Our Ref: BR/306/19/HH

**Town & Country Planning Act 1990 (as amended)
Town & Country Planning (Development Management Procedure) (England) Order 2015
Application for Planning Permission for Works or Extension to a Dwelling**

Development Proposed two storey side and rear extension, single storey rear extension, with replacement front porch.

Location 28 Arun Road Bognor Regis

Proposed Site Plan at 1:500 scale

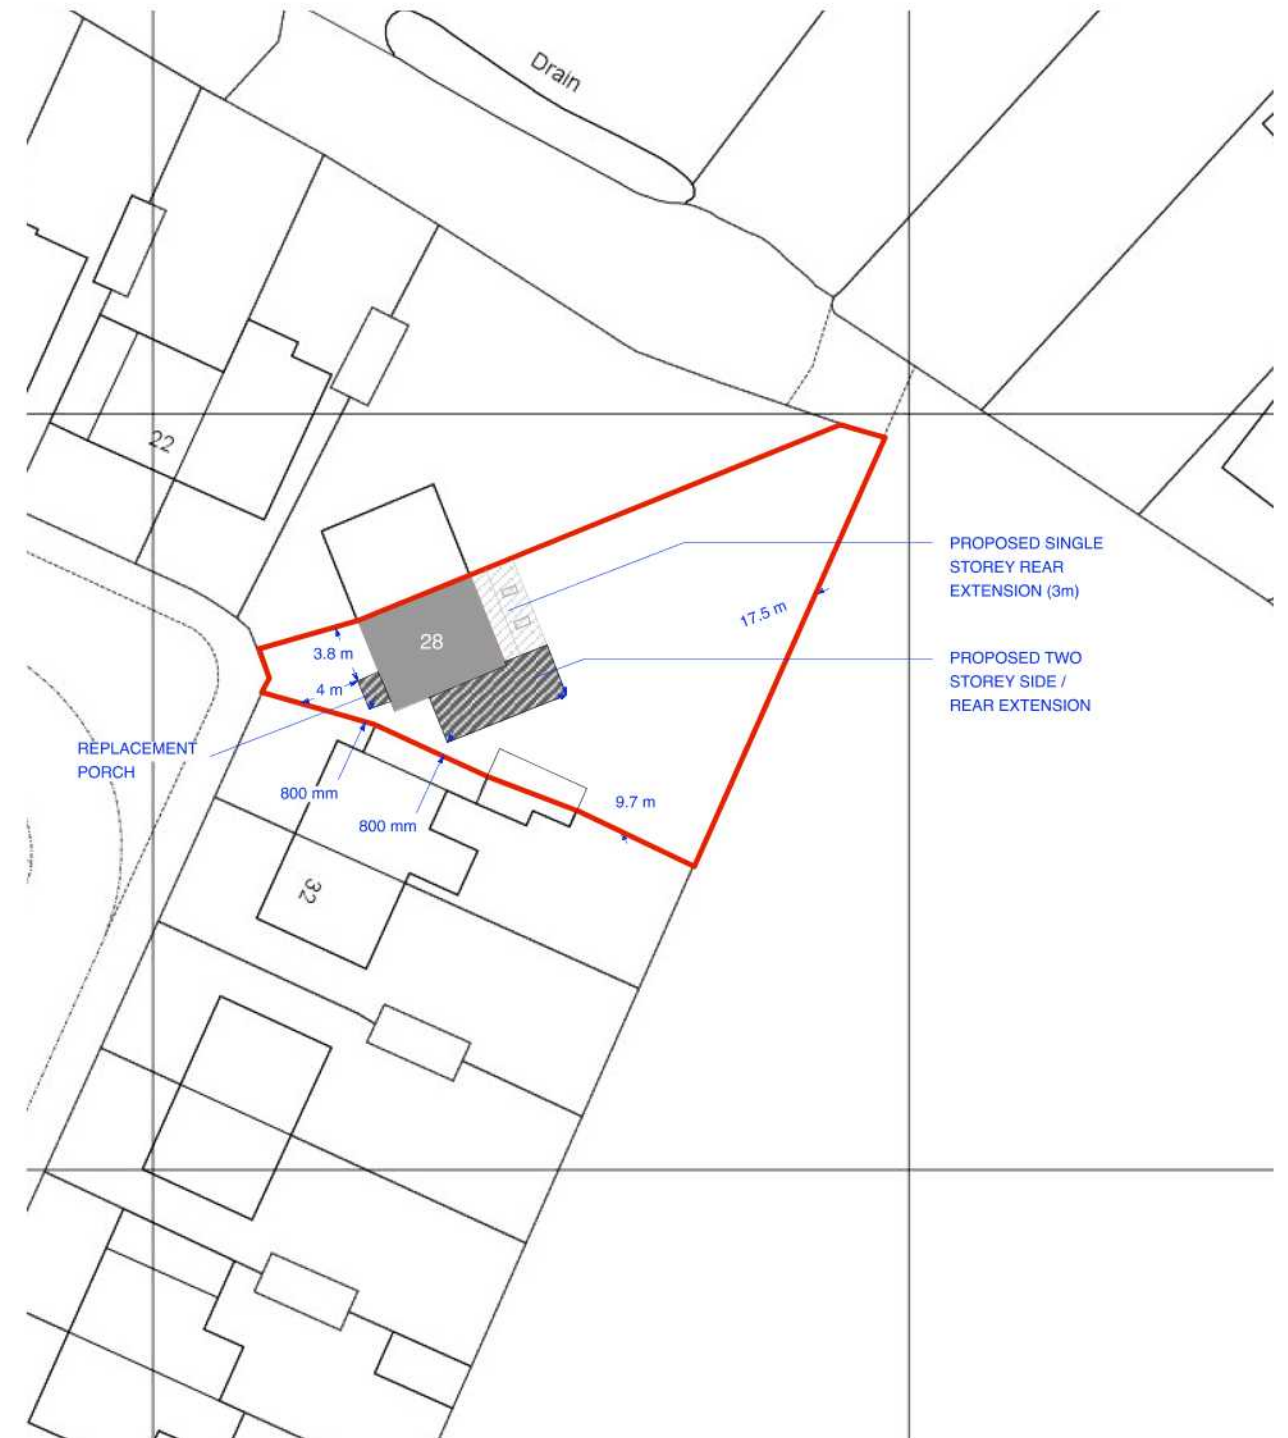
Block Plan: You are required to include dimensions on the block plan from the porch to all site boundaries.
